TECHNICAL NOTE

DATE:	06 October 2022	CONFIDENTIALITY:	Public
SUBJECT:	WSP Response to EA Comments		
PROJECT:	Bognor Golf Course Hydraulic Model	AUTHOR:	Andy Smith

This Technical Note has been produced to provide a detailed response to the Environment Agency's comments on the hydraulic model which was developed to support the Hallam Land Management Ltd planning application for the redevelopment and relocation of the existing Golf Course (HA/2022/124003/01 and HA/2022/124004/01).

## HYDRAULIC MODEL RESULTS

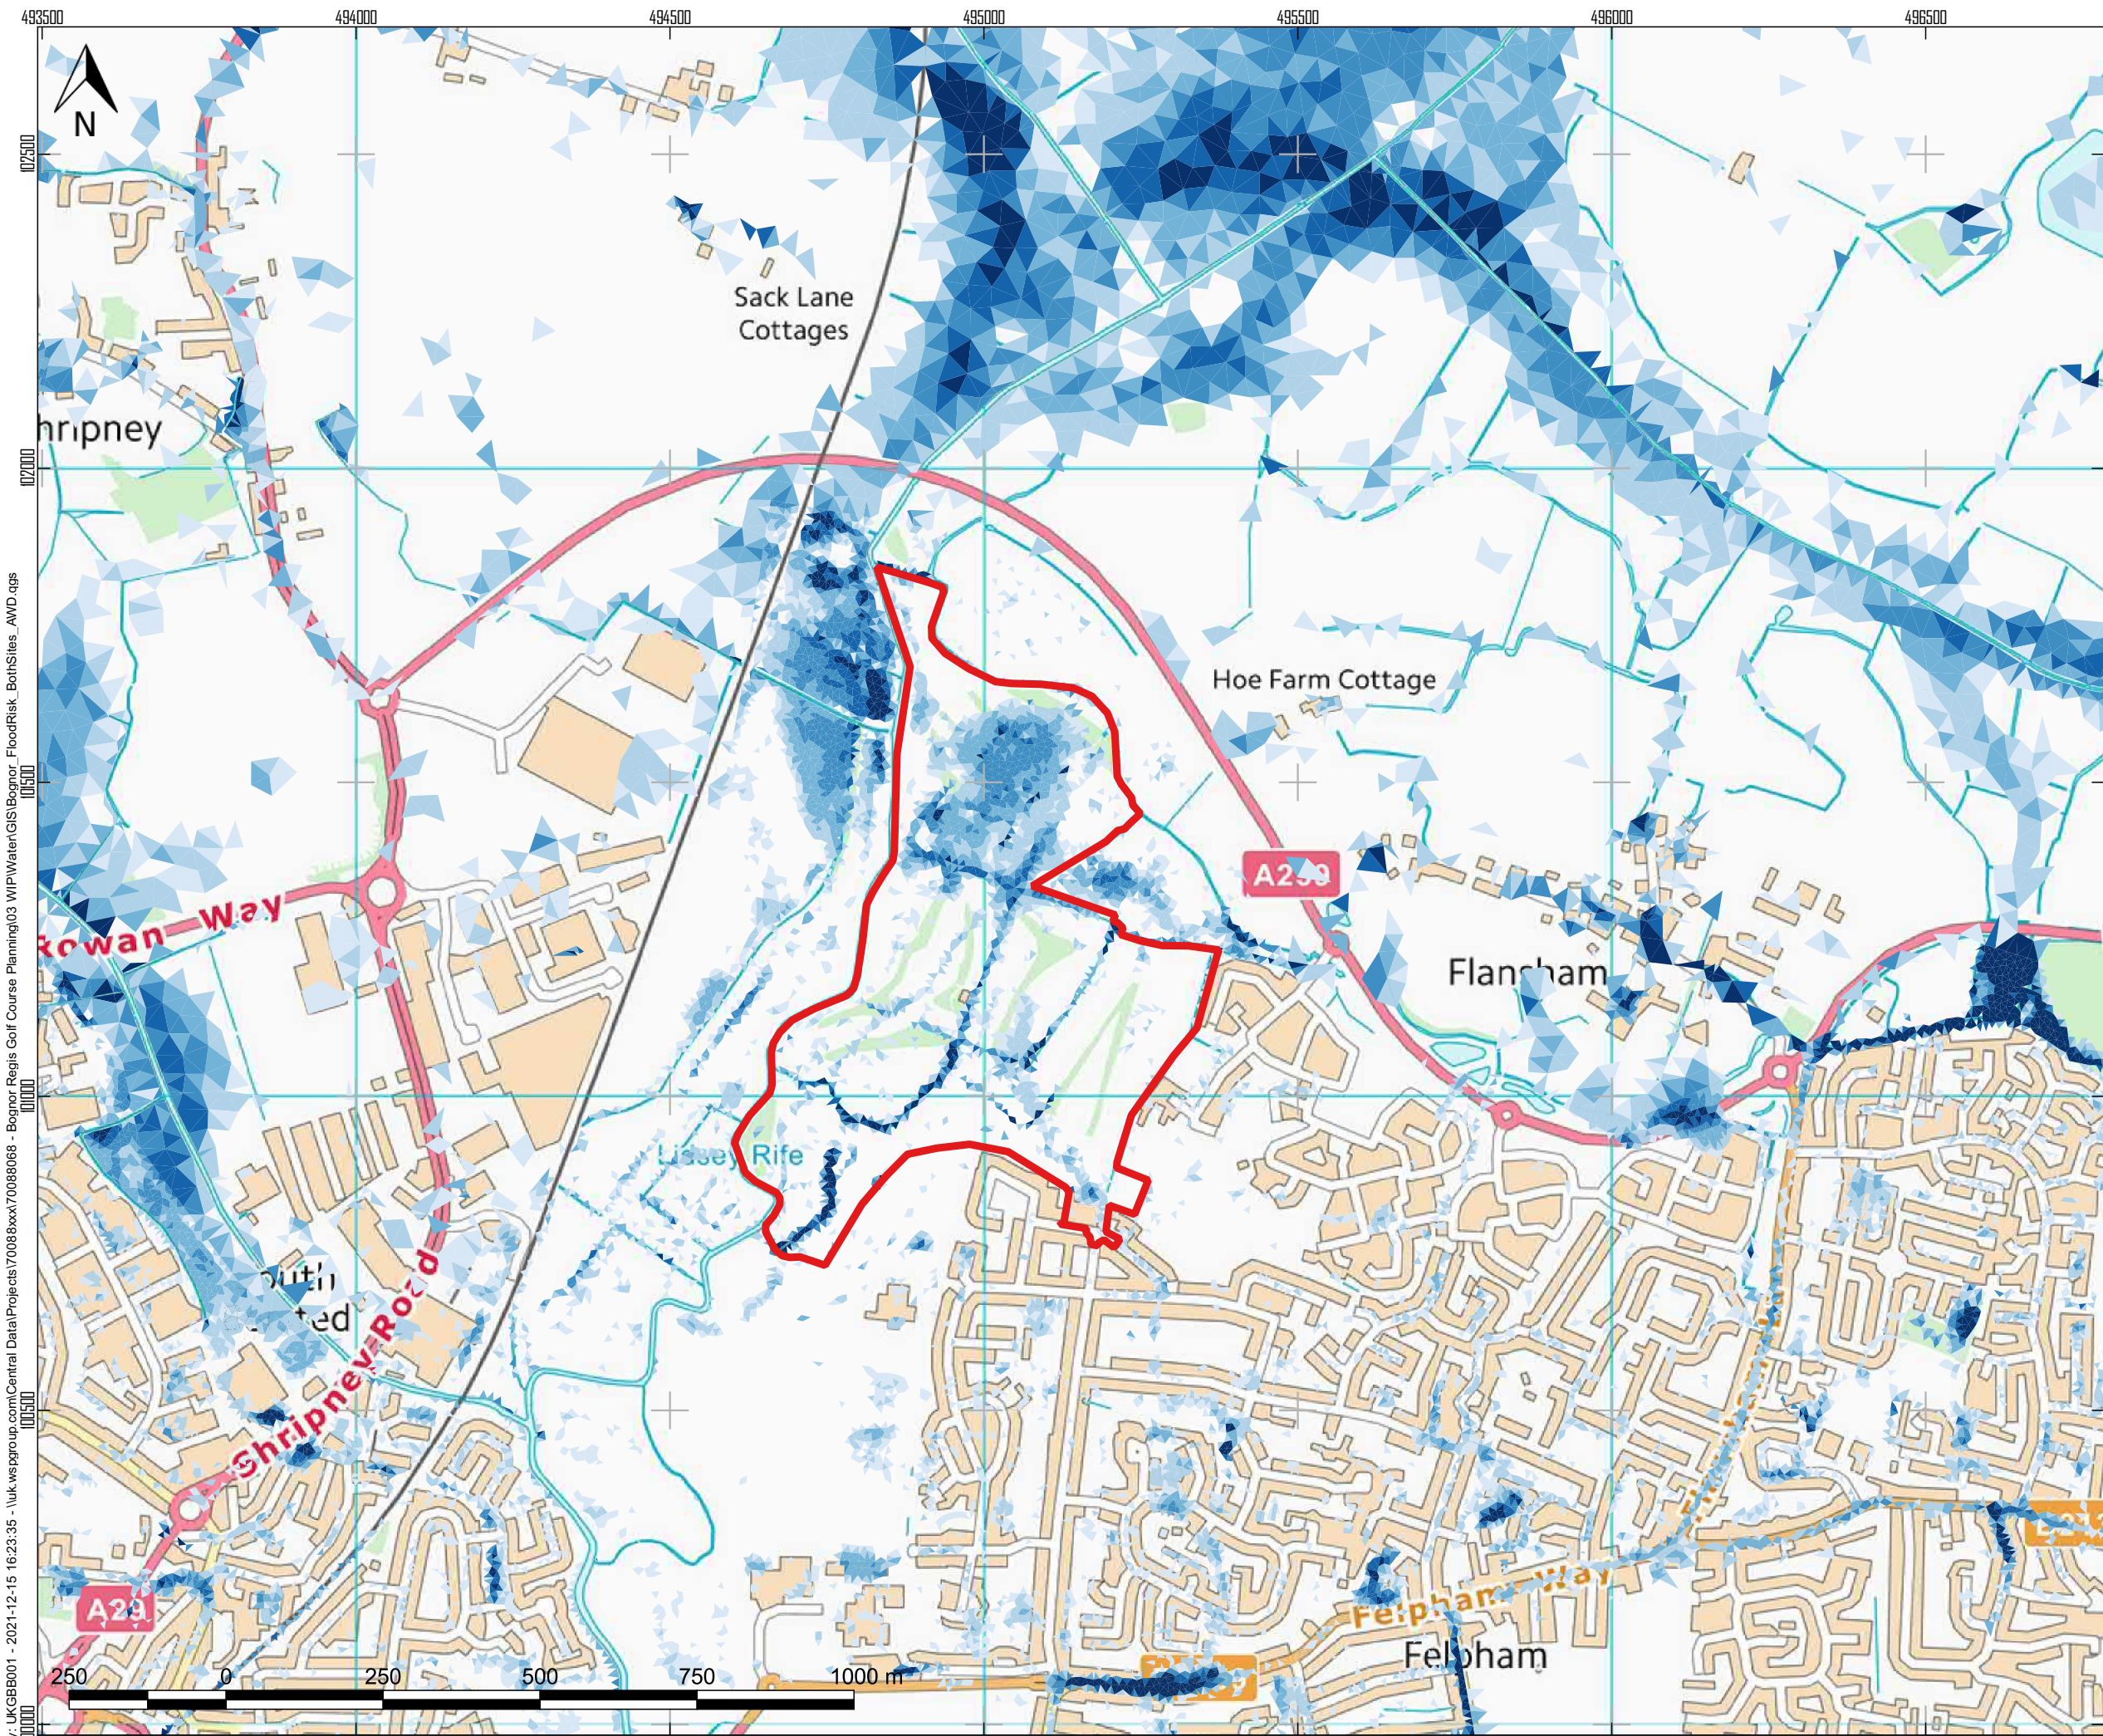
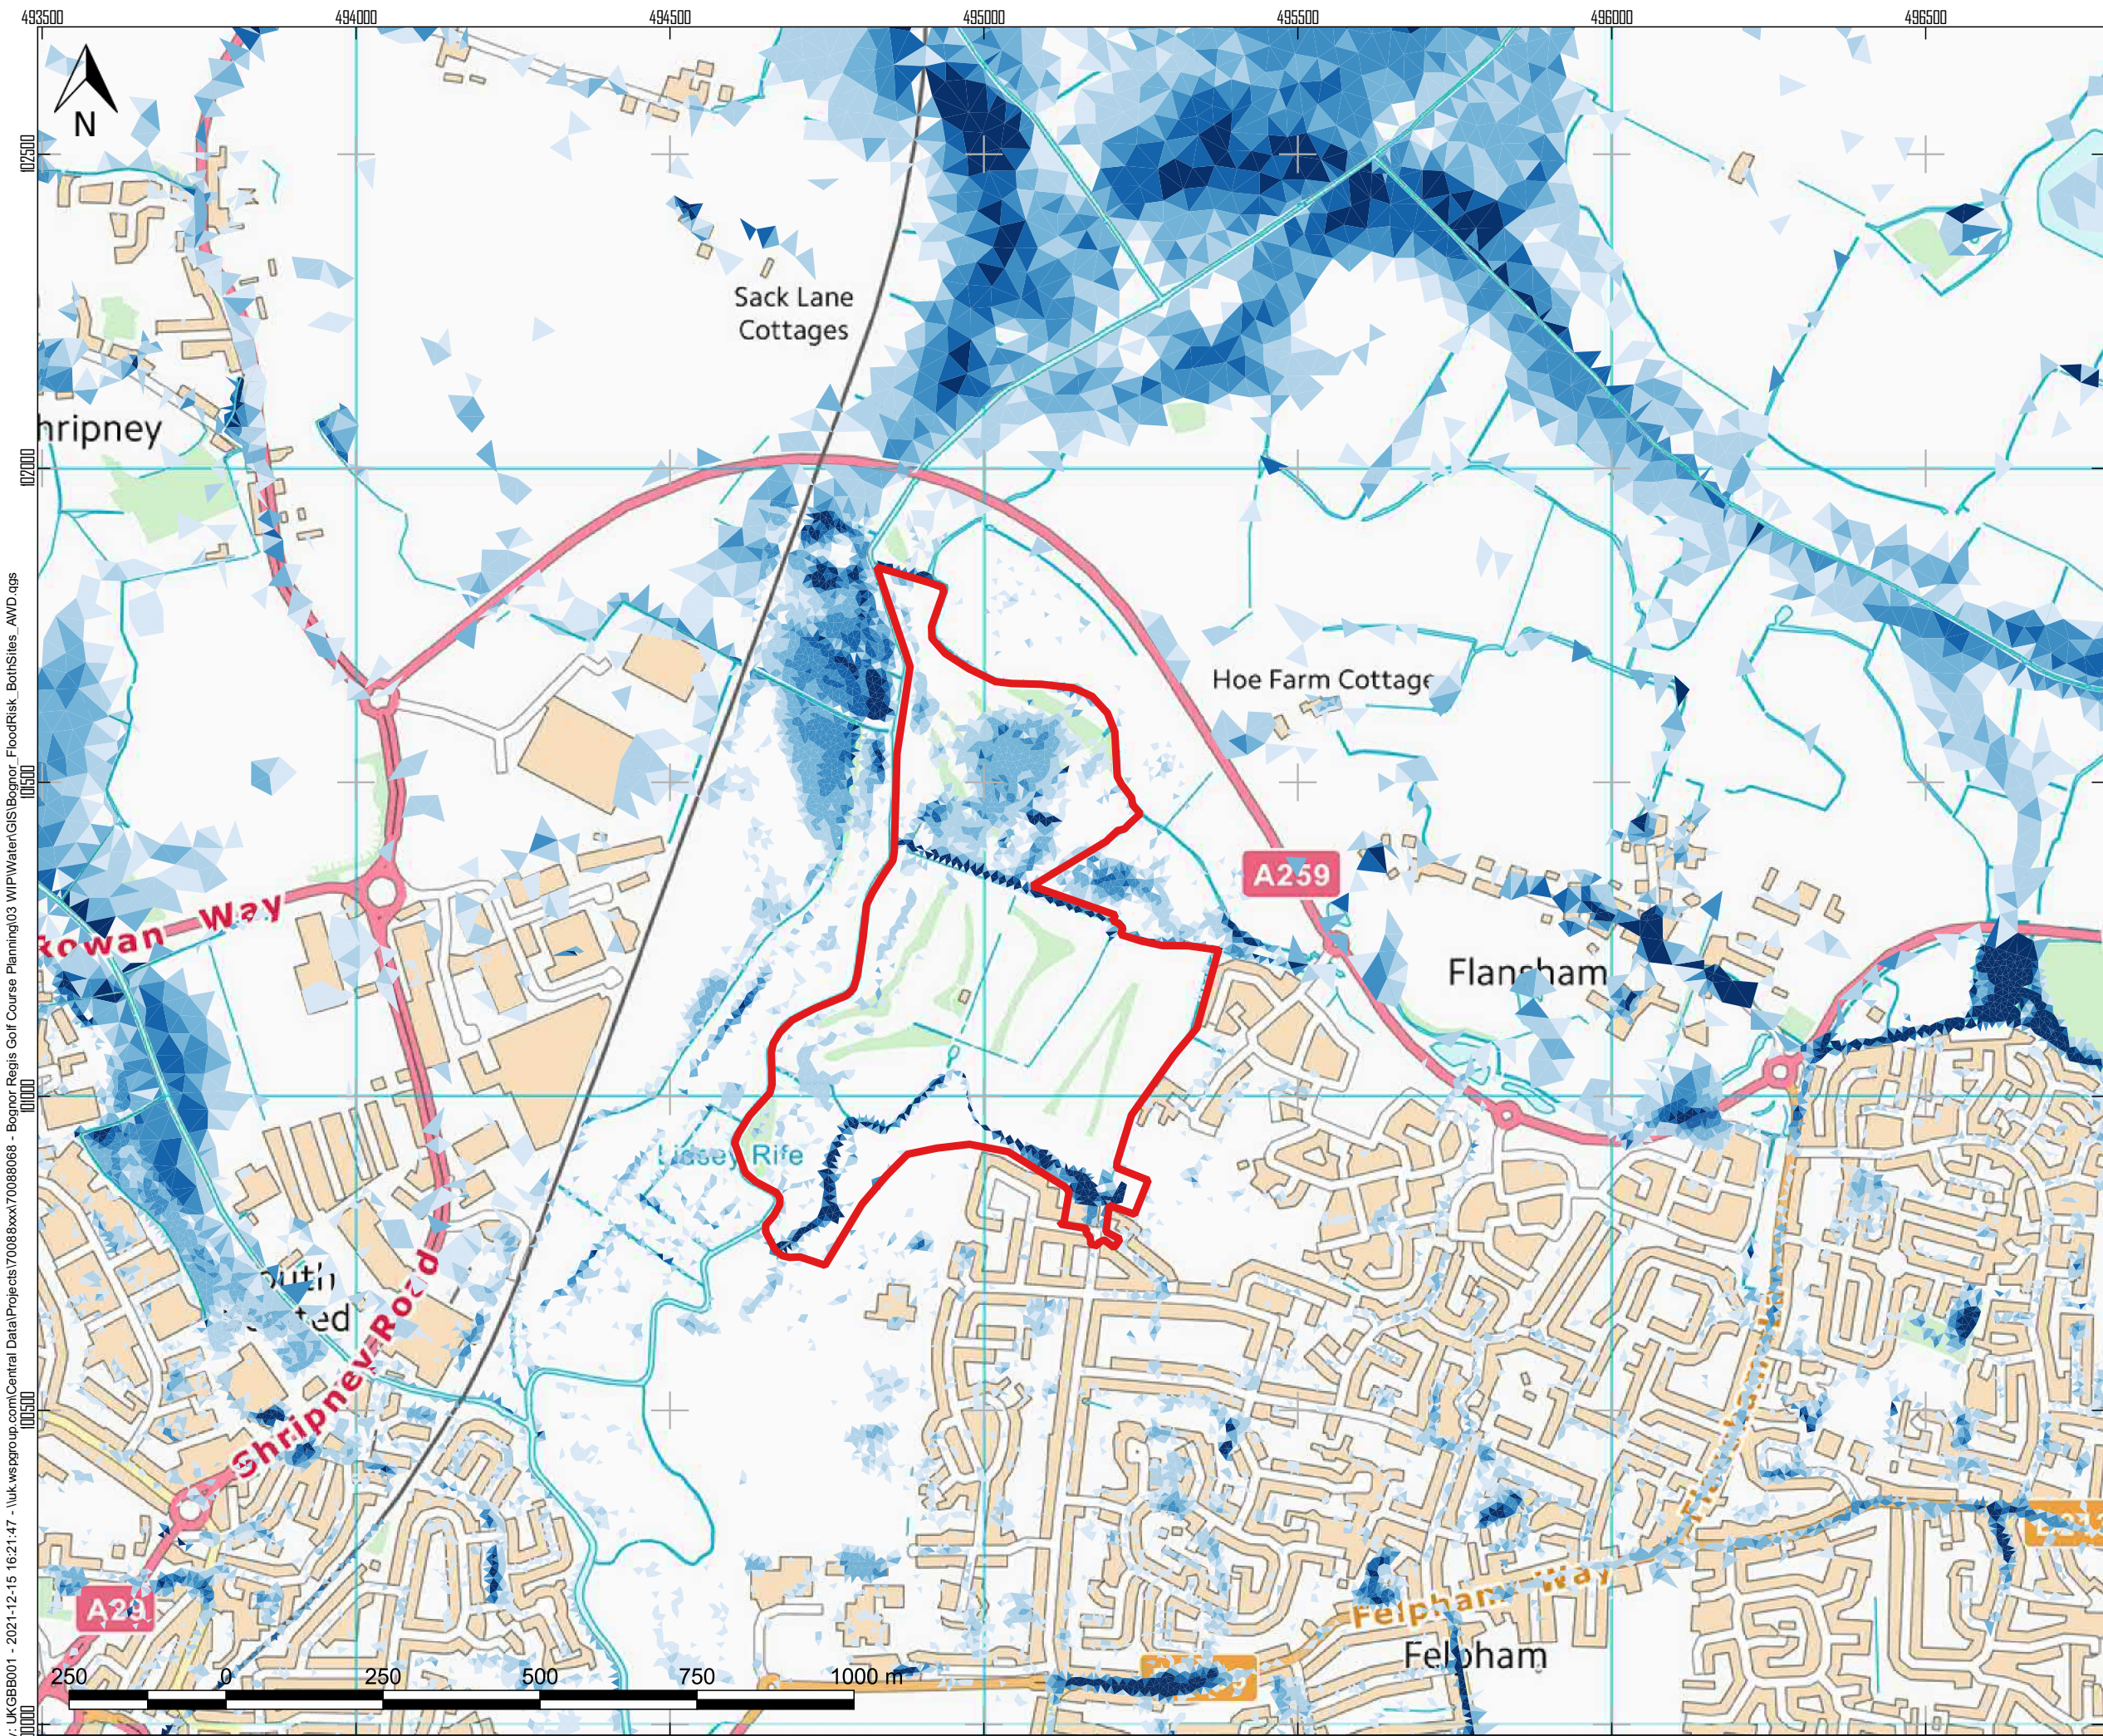
3. *Some of the differences between the baseline and proposed model results could be driven by the difference between the baseline ground model and the updated ground model as noted in item 7.3 (worksheet 2D Model Build) of this model review. Please investigate this. It would also be prudent to assess detriment across a wider range of AEP scenarios and present the results in the reporting.*

In line with the comments provided for point 2, the ground models have been updated, this now demonstrates that there are no detrimental impacts outside of the red line boundaries, across the range of AEP scenarios. Please see the appended maps.
